# CITY OF ALBUQUERQUE

**Re: Luna Vita Subd  
Erosion and Sediment Control Plan  
CPESC's Stamp Date 6-27-19 (C19E066)**

Based upon the information provided in your submittal received 6-28-19, the above referenced plan is approved to be included in the SWPPP and for NOI documentation review for grading, WO and Building Permit with the following conditions:

TEMPORARY EROSION AND SEDIMENT CONTROL PLAN

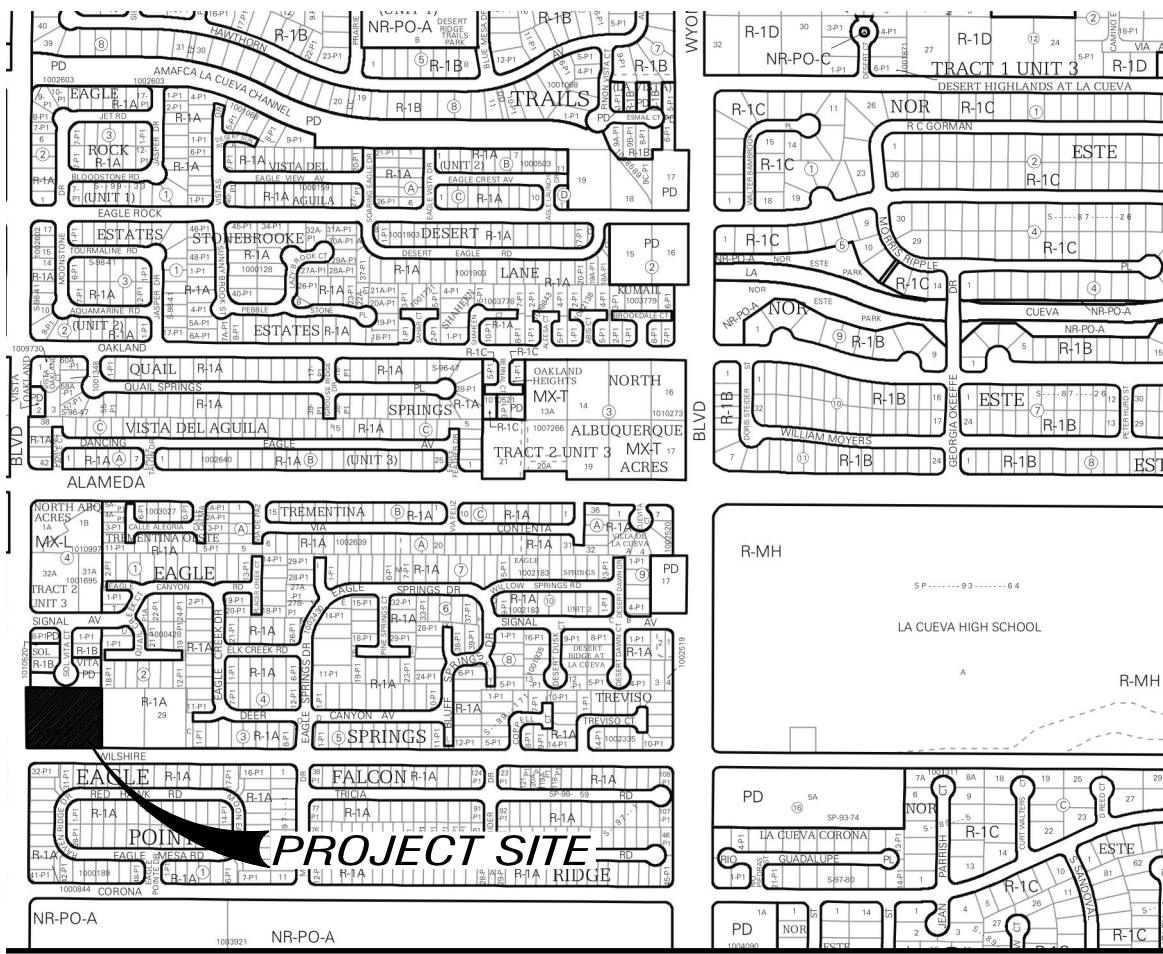
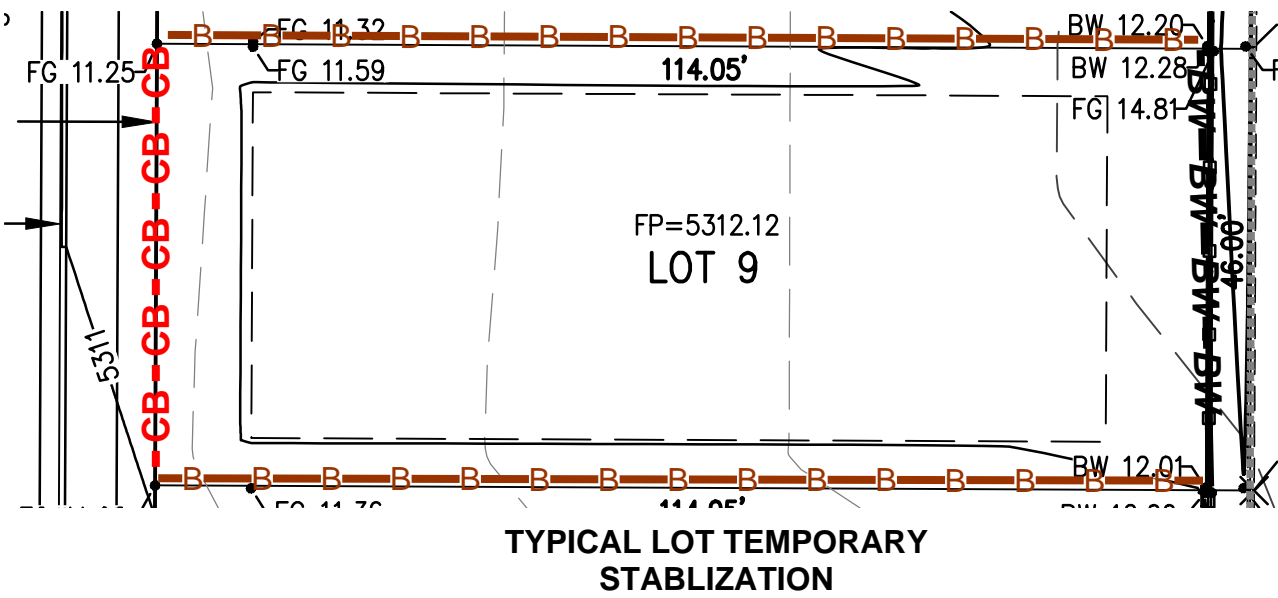
1. The southern edge of the silt fence should be shifted south so that it is closer to the road as the area between the lots and the edge of pavement will most likely be graded at the same time.
2. Provide a mulch sock or similar sediment BMP at the west end of Wilshire Ave when the street work is occurring.
